Consultation Response from Chris Bembridge KC, Highways Development Management
2023/91280 Bromley Farm Quarry, Barnsley Road, Upper Cumberworth, Huddersfield, HD8 8PD
Quarrying operations for the extraction of clay, shale and incidental coal and subsequent restoration by means of importation of inert wastes
Date Responded: 21/02/2025 Responding Officer: CNB Responding Ref: K17-3/6

This application is for the formation of a new quarry utilising the existing access of a previous and now depleted and restored quarry on to A635 Barnsley Road, a 40mph two-way single carriageway primary distributor road of approximately 9m width with footways on the side of the application site and street lighting present. There is a hatched central reserve and a right turn lane in to the site.

**SITE OFFICE & WHEEL BATH
LOCATION**

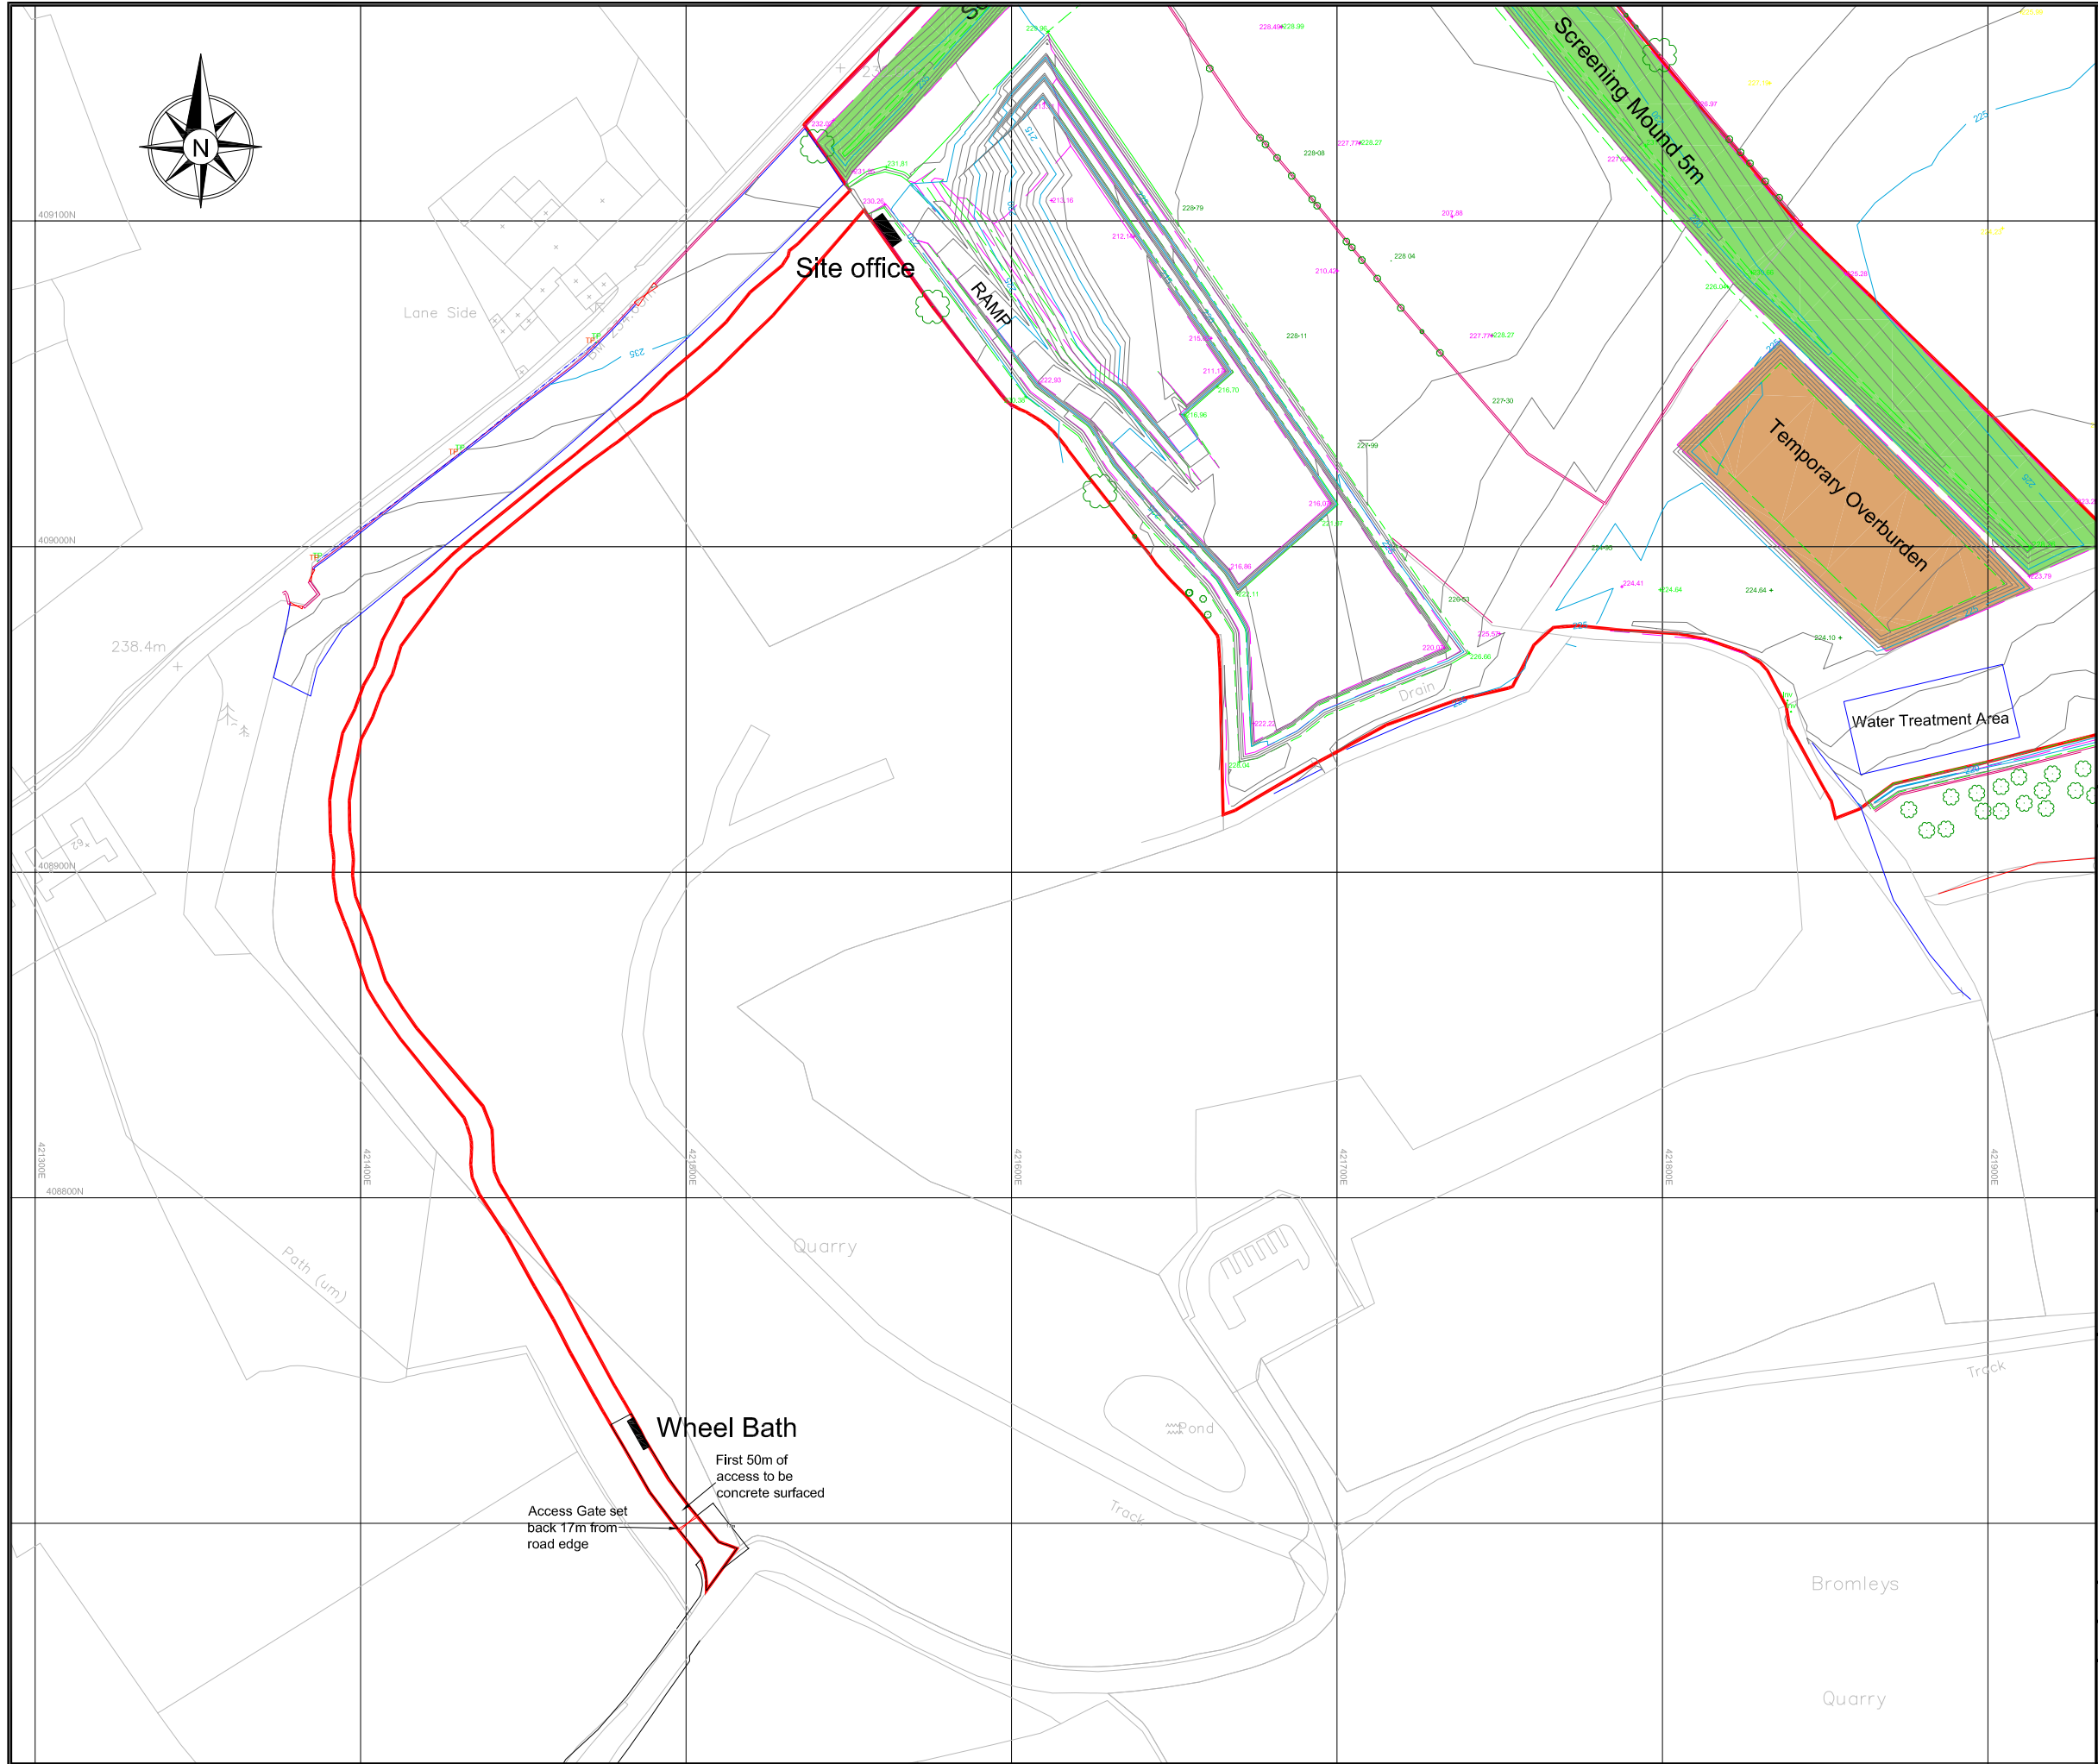
Drawing No 101A shows that the first 50m of the quarry access will be hard surfaced and drawing No 22007/513 Rev B shows the location of wheel washing facilities and combined these should stop mud and debris from being dragged on to the shared access road. The use of and responsibilities for the wheel washing facilities can be included in the Access Management Plan condition.

Prior to the site being brought in to use, wheel washing facilities shall be installed as indicated in drawing No 22007/513 Rev B. No commercial vehicles shall enter the access road, which runs between the site entrance and the A635 Barnsley Road, or the public highway from the permitted site unless their wheels and chassis have been cleaned to prevent material being deposited on the access road or
